**From:** Contact Centre (CRM) <contact@ribblevalley.gov.uk>  
**Sent:** 28 February 2023 16:47  
**To:** Planning  
**Subject:** Planning Application Comments - 3/2023/0107 FS-Case-491929983

**Planning Application Reference No.: 3/2023/0107**

**Address of Development:** Overdale, York Lane, York, Langho, BB6 8DT

Drawing title  
Proposed Floor Plans and Elevations

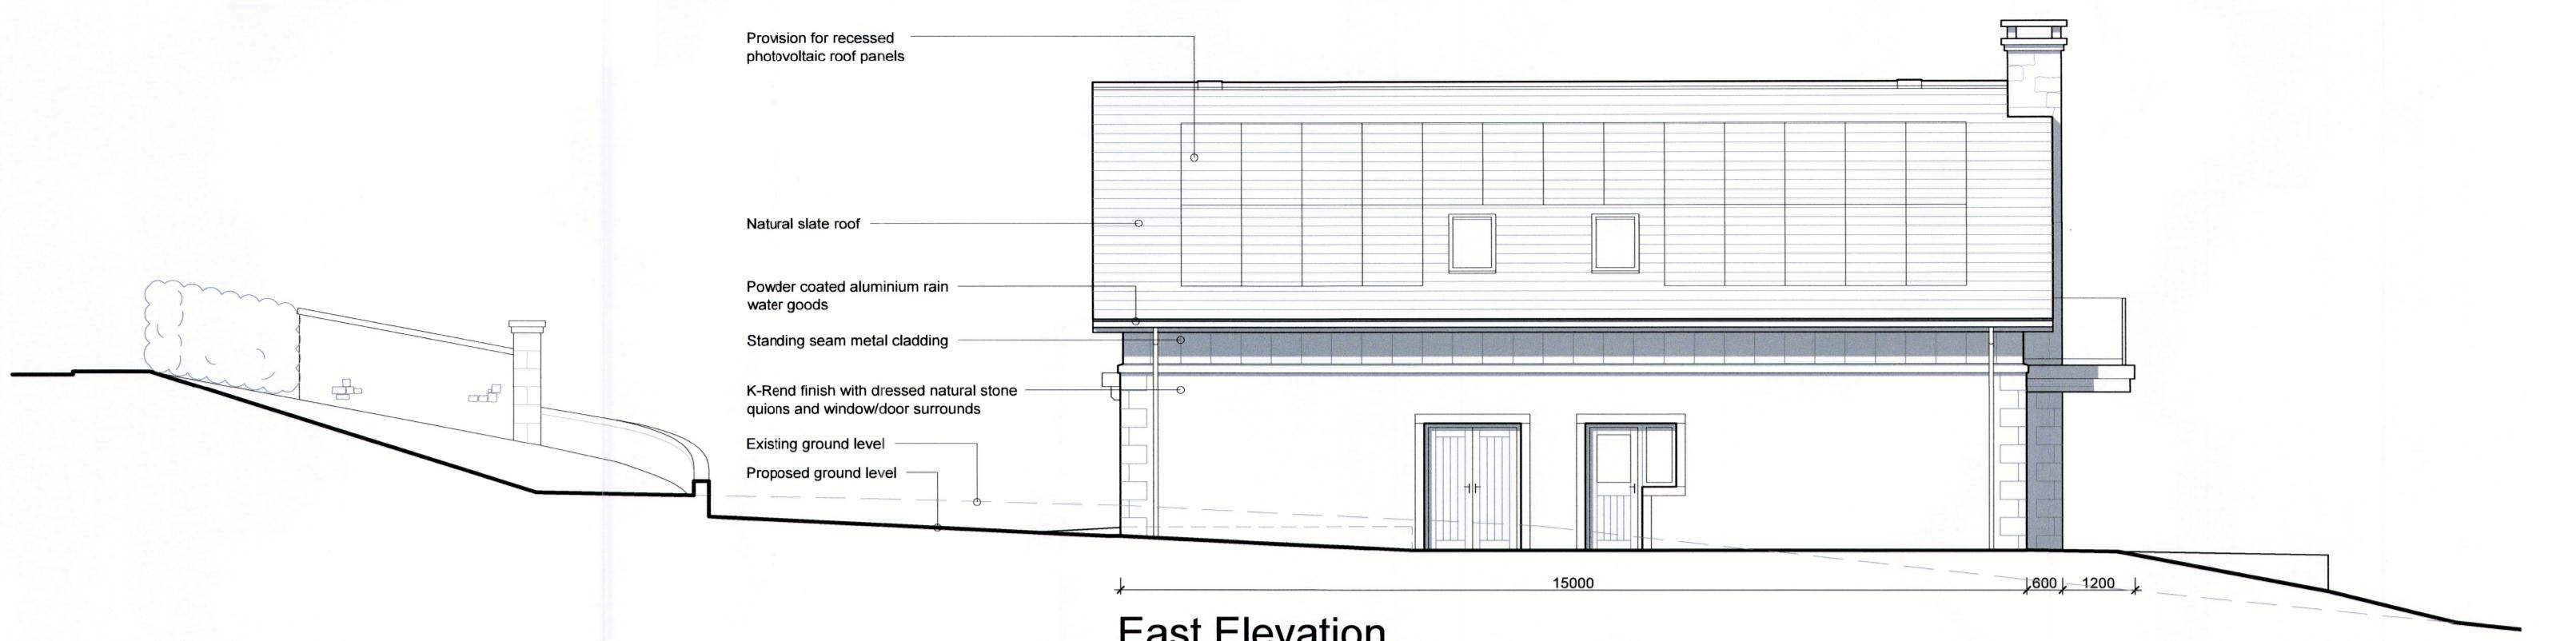
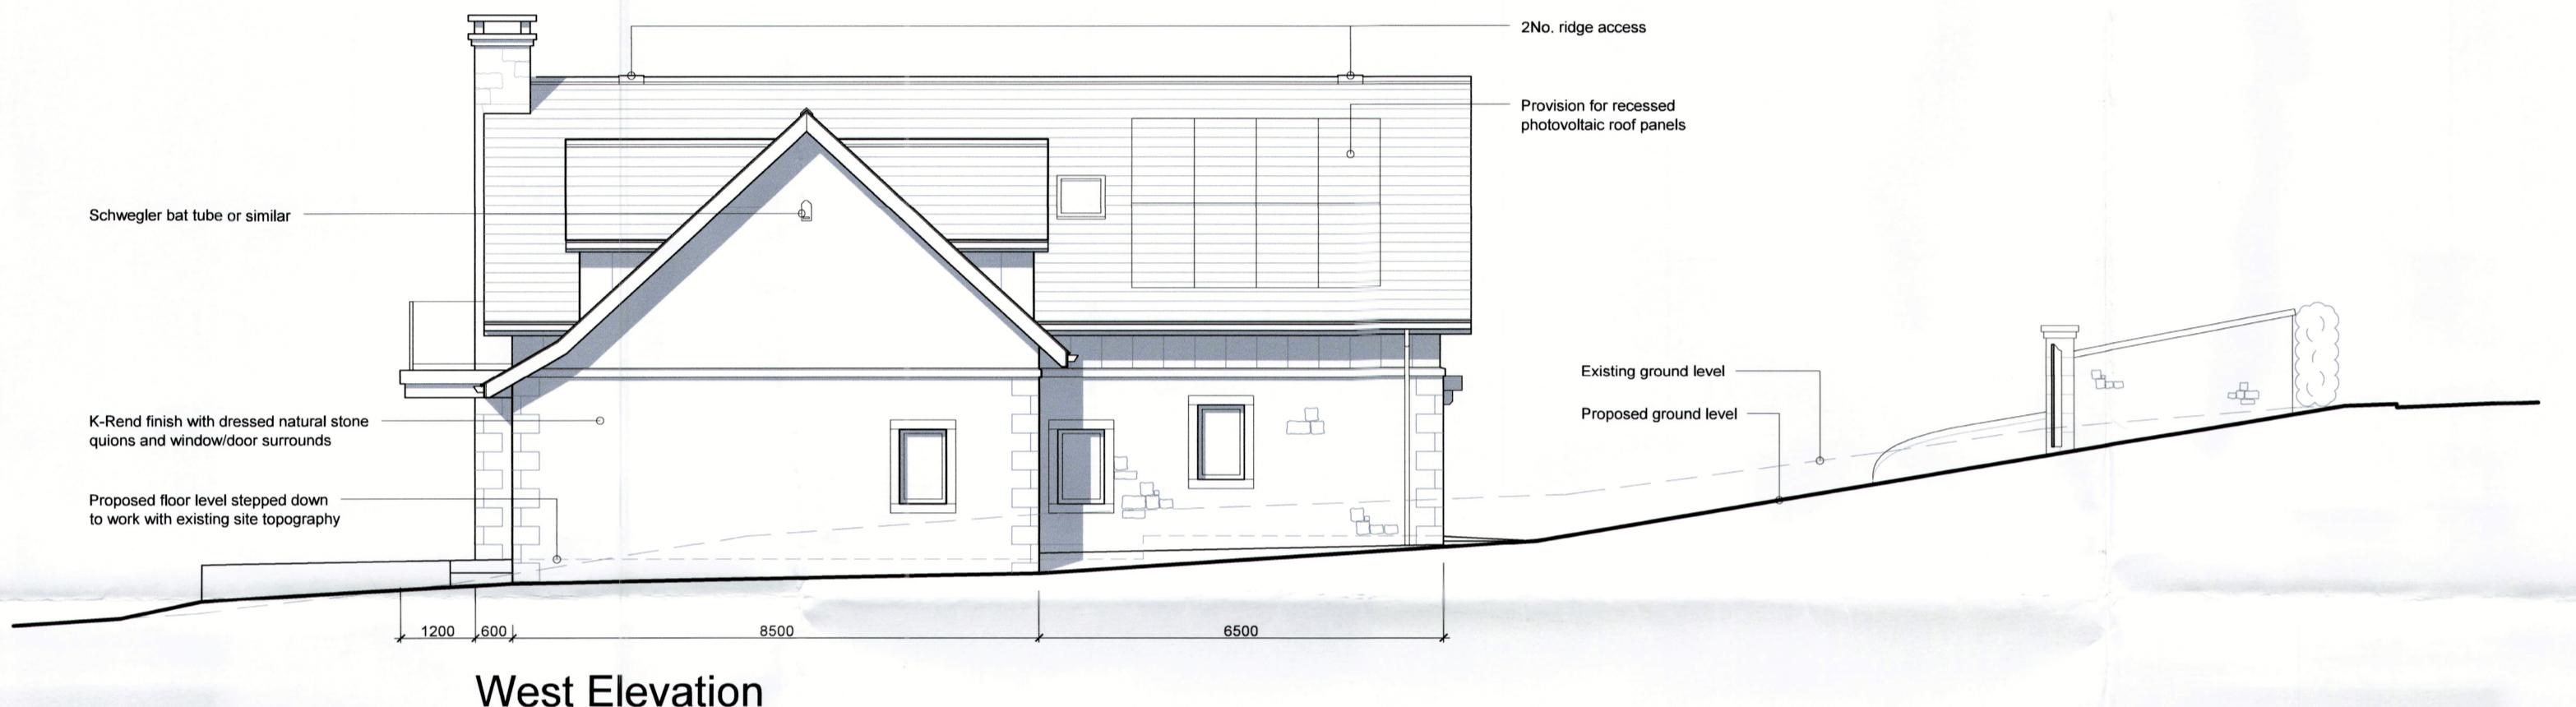
2. The main focal point of the proposed replacement building is the very large gable end to the front which it has been specified to be zinc clad. Again, this differs considerably from the previous approved application in which careful consideration had been taken over specified materials to be sympathetic to the facing properties and overall feel of the area. The local stone as originally approved would be far more in keeping with the village of York than metal cladding. The only deviations from these more traditional building styles can be seen in pre-fab buildings constructed circa post-war era which were erected before the existence of the green belt and should not be seen as setting precedence to further deviate from maintaining stone construction wherever possible.

1. The ridge height of the proposed replacement building appears, upon inspection of the site section document, to be considerably higher than the existing building and indeed higher than the neighbouring properties on either side. This was not the case with the previously approved planning application where care had been taken to reduce the impact of the overall build height by keeping the ridgeline as low as possible and also siting the property further back and thus lower down on the plot.
